KIRKLEES METROPOLITAN COUNCIL INVESTMENT & REGENERATION SERVICE

DELEGATED DECISION TO DETERMINE APPLICATIONS FOR NON-MATERIAL AMENDMENTS

Reference No: **2022/NM/92824/E**

Site Address: Former North Bierley Waste Water Treatment Works,
Oakenshaw, BD12 7ET

DRAWING NO: 2115 PL 131

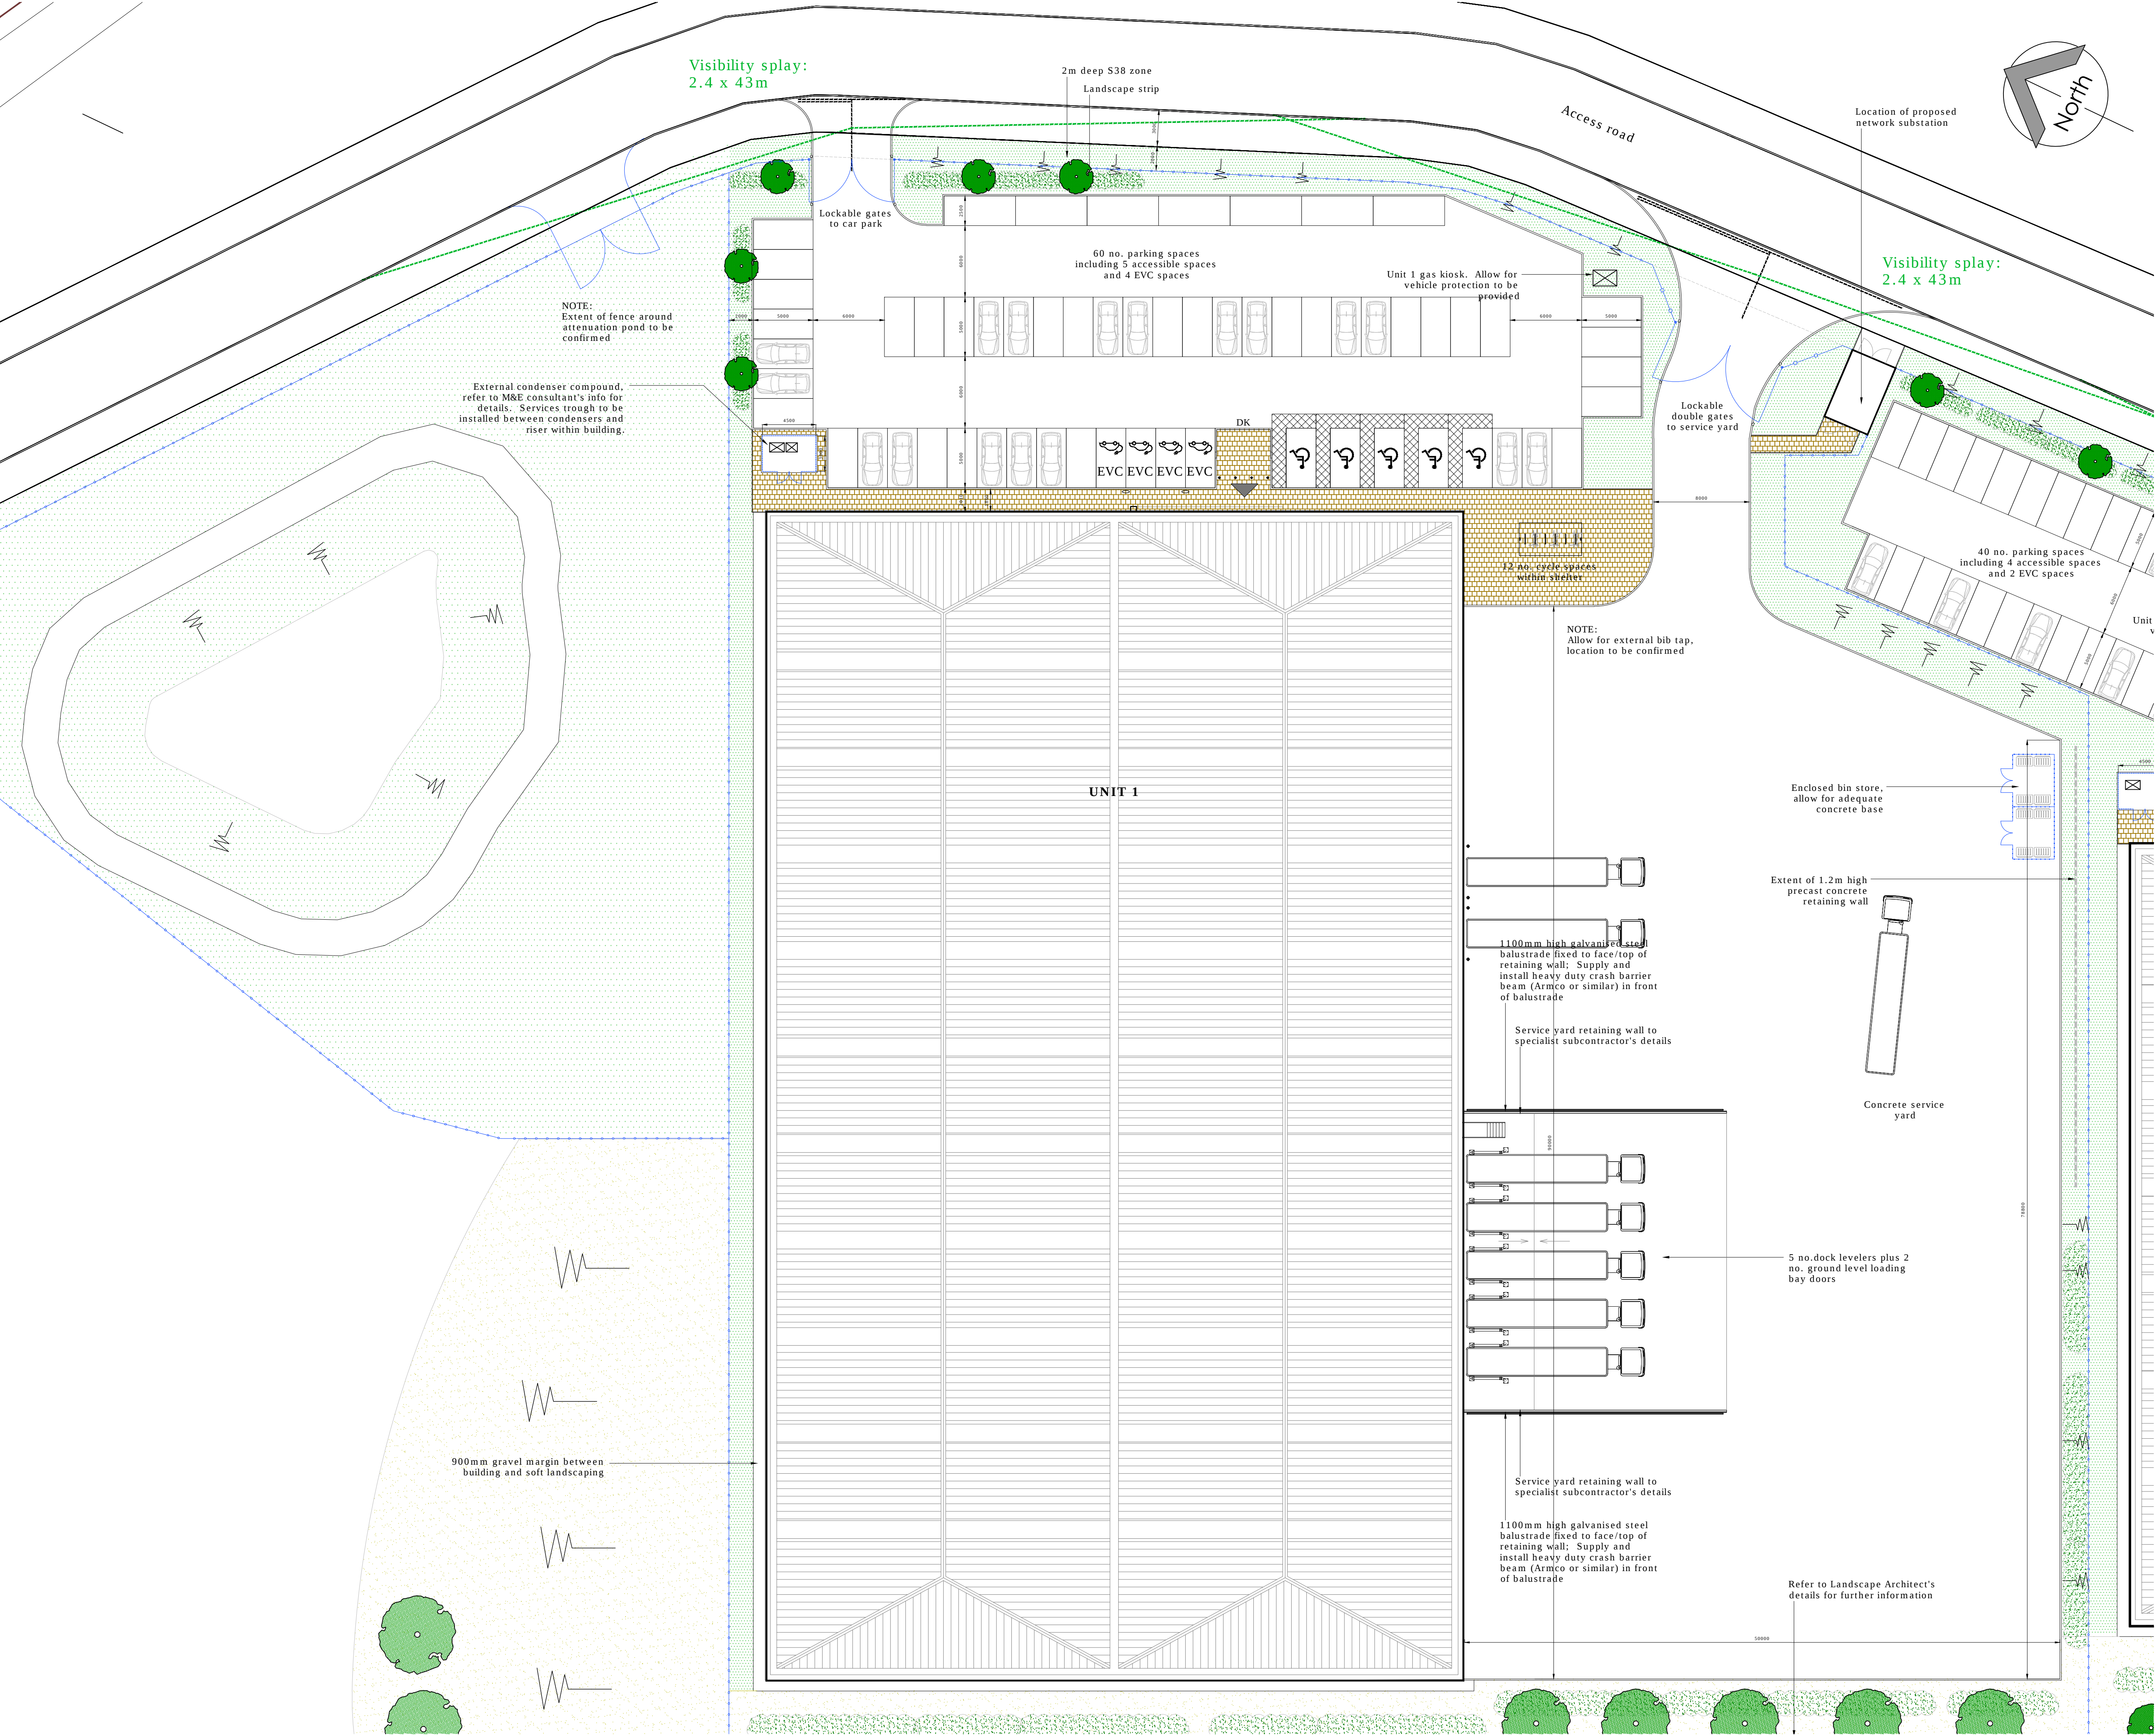
- Changes to the car park layout (unit 1)

The number of car parking spaces would remain the same, with that sought being a reshuffle. The ratio and location of accessible parking spaces also remains. The layout changes would not impact upon the car park's ability to function effectively, nor would it encroach into landscaping area.

It should be noted that the layout changes do remove some landscaping: this change is in response to necessary amendments to the road as part of the S38 process and is not opposed.

DRAWING NO: 2115 PL 133

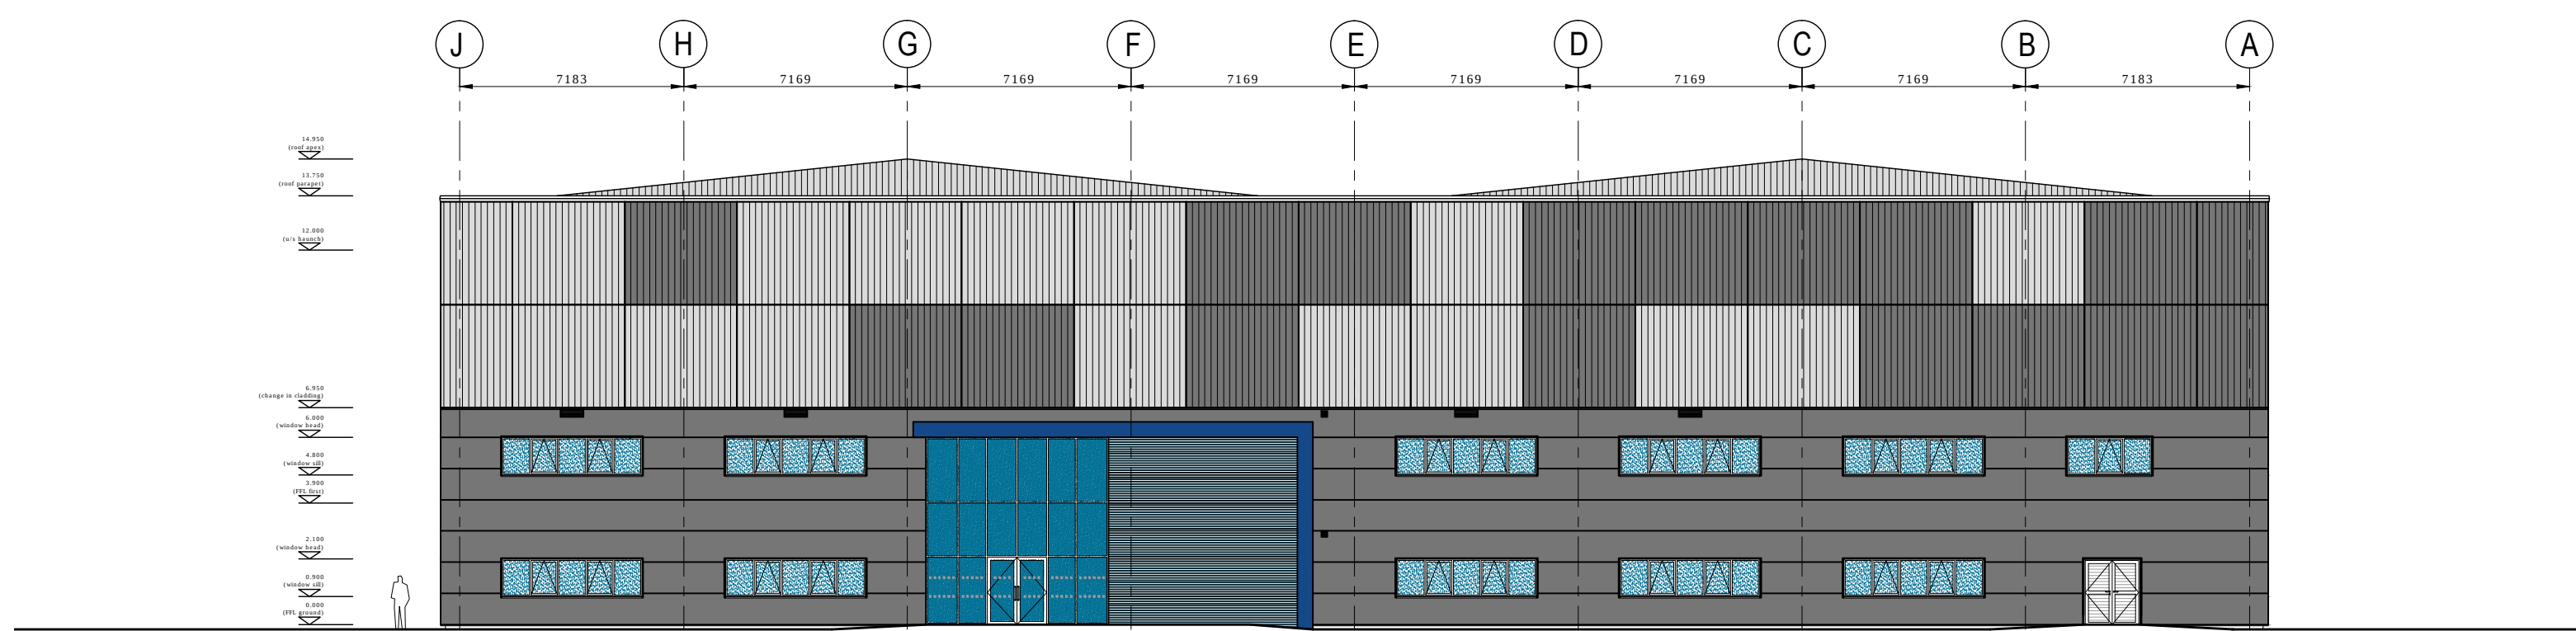
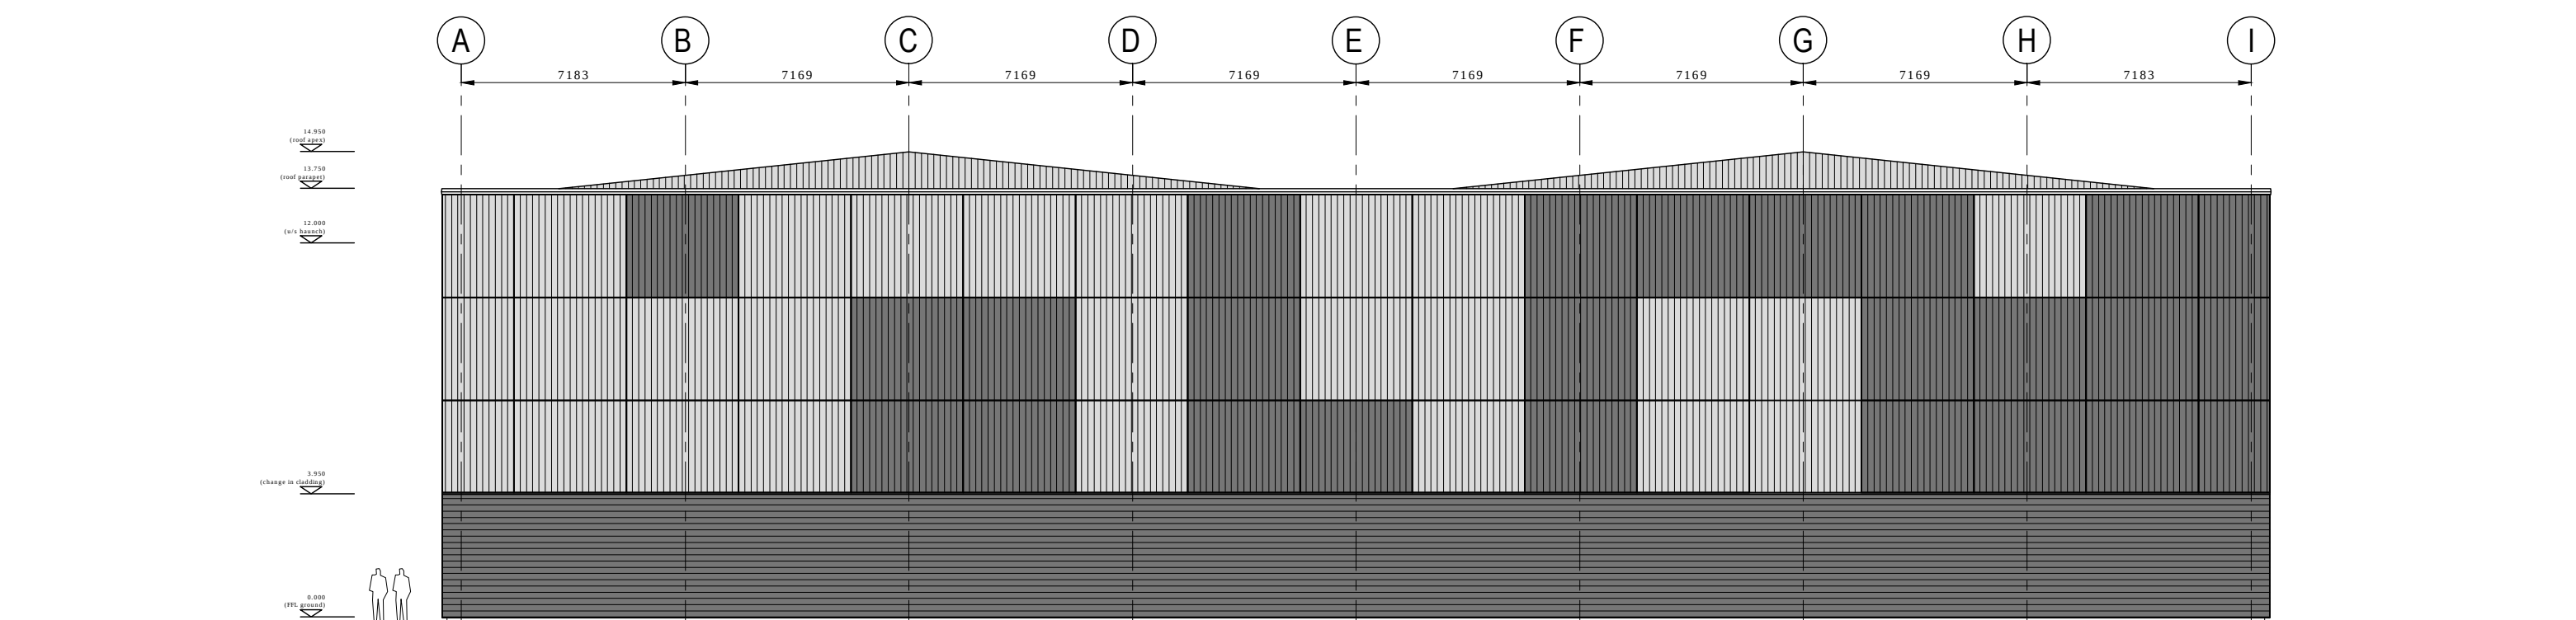
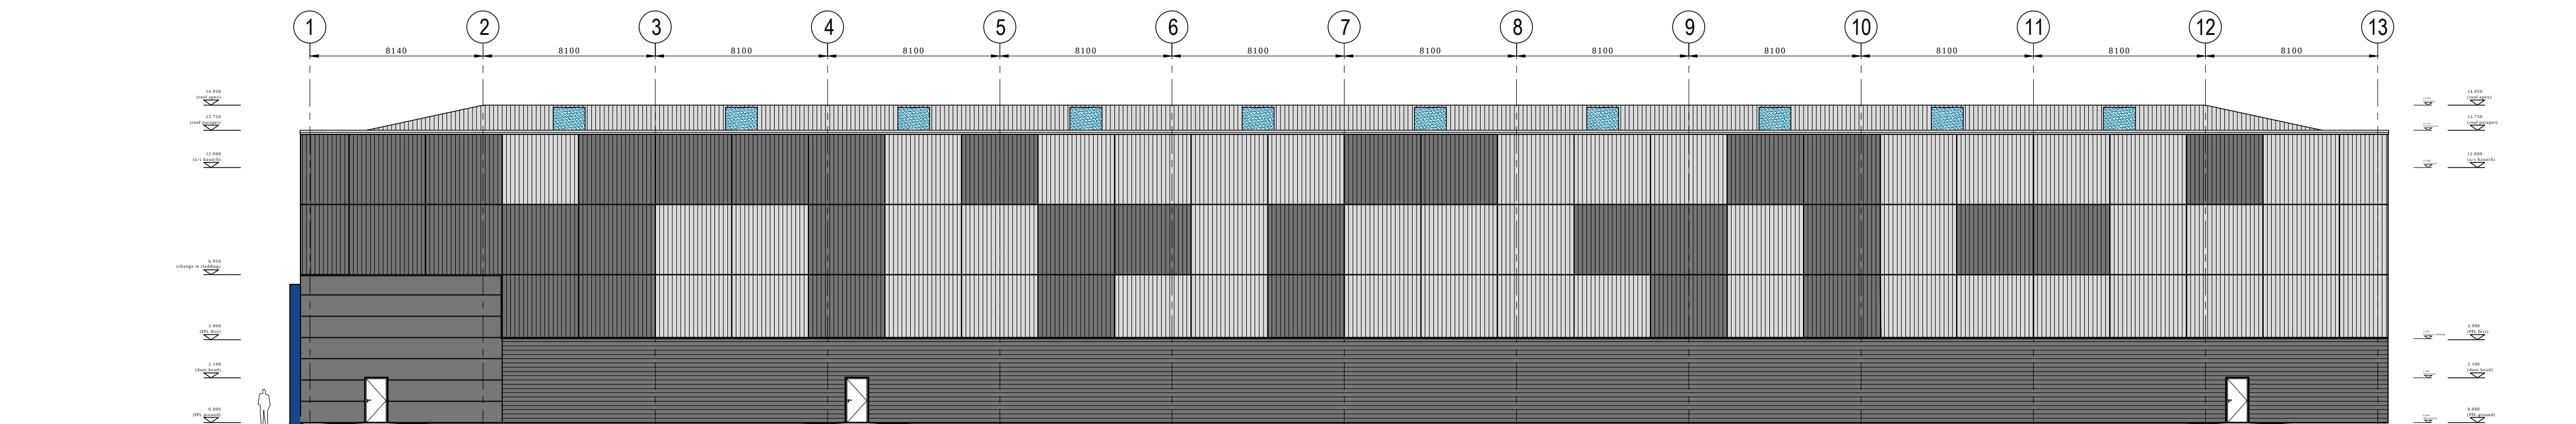
- Changes to elevations (changing brick surround of dock doors to insulated concrete).
-

The elevational changes are minor in nature. The change from brick to concrete covers a small area on each building. It is not expected to cause either buildings' appearance to be visually worse, nor materially different to the casual observer. Fundamentally these are utilitarian commercial buildings, and this appearance and character will be unaffected by the proposal.
